Job Code: CD3216                      Project: Heyford Park Village Centre

Date Issued: 30/6/2017              Revision: S2-P2

Building 457 - Proposed North Elevation
1 : 100

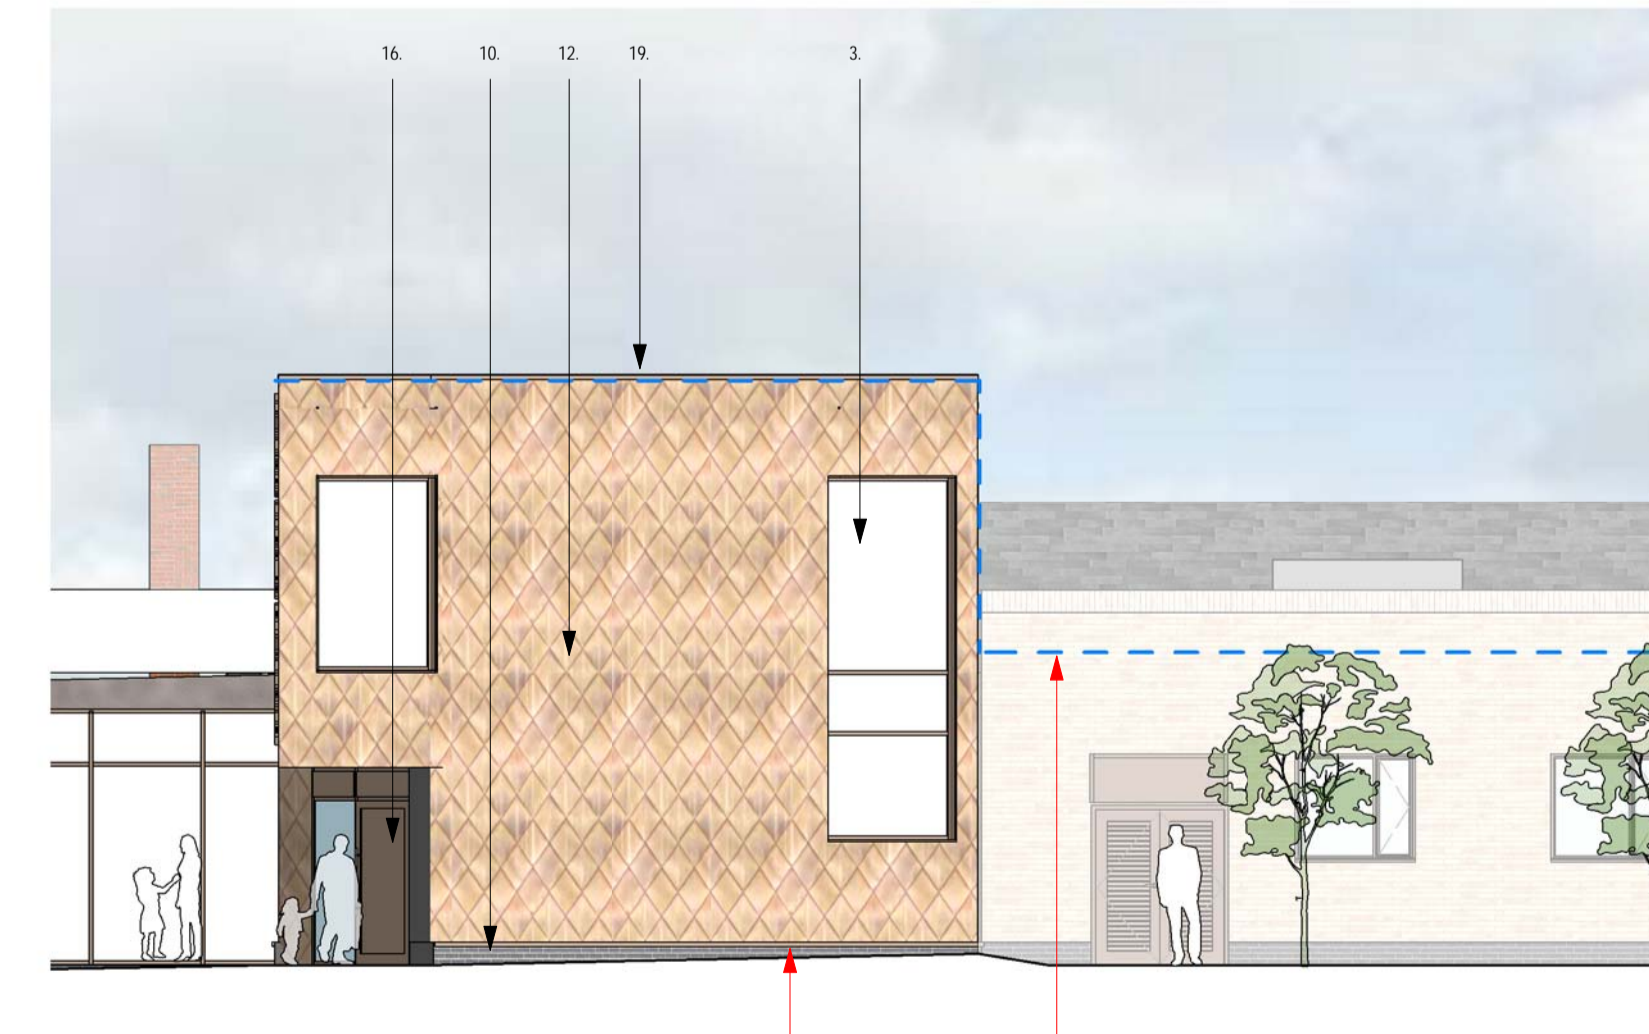
3.1	Increased height of first floor FFL, flat roof, plant deck and parapet over new build elements due to coordination of structural frame and M+E services (1100mm high parapet required from a CDM standpoint to avoid the need for a mansafe/ fall-arrest system to plant deck.

3.2	Refuse Store and Plant Room rearranged at ground floor to enable easier distribution of M+E services throughout the building and to reduce duct lengths/ sizes. Additional door added to accommodate M&E requirements

3.3	Omission of glazed roof over ground floor circulation areas (replaced with insulated flat roof with single-ply membrane) and increased height of parapet for continuous 1100mm parapet around roof plant area.

3.4	Adjustments to ground and first floor WC arrangements to enable efficient coordination of SVP's/ drainage connections and has led to subsequent relocation of external windows.

3.5	Demolition of existing 'spine wall' to back of house area due to potential instability during construction works.
3.6	Fire exit door added to Stair 1 to provide those evacuating from the first floor immediate exit to outside once down the stairs.

3.7	Removal of single leaf door on first floor to terrace
3.8	Removal of double doors to existing western gable elevation following reconfiguration of restaurant and kitchen layout.

3.9	Removal of double doors to existing south elevation following reconfiguration of internal restaurant and kitchen layout.
3.10	First Floor level increased following updated measured survey information.

3.11	Increased height of first floor FFL, flat roof, plant deck and parapet over new build elements due to coordination of structural frame and M+E services . Masonry elements increased to allow for this space and align with metal cladding elements (removal of 1100mm parapet as no roof plat to this area.)

3.12	Dark grey brick plinth added, following design development
3.13	Window replaced with door to provide external delivery access to Bar Store
<b>4.0</b>	<b>Covered Link</b>
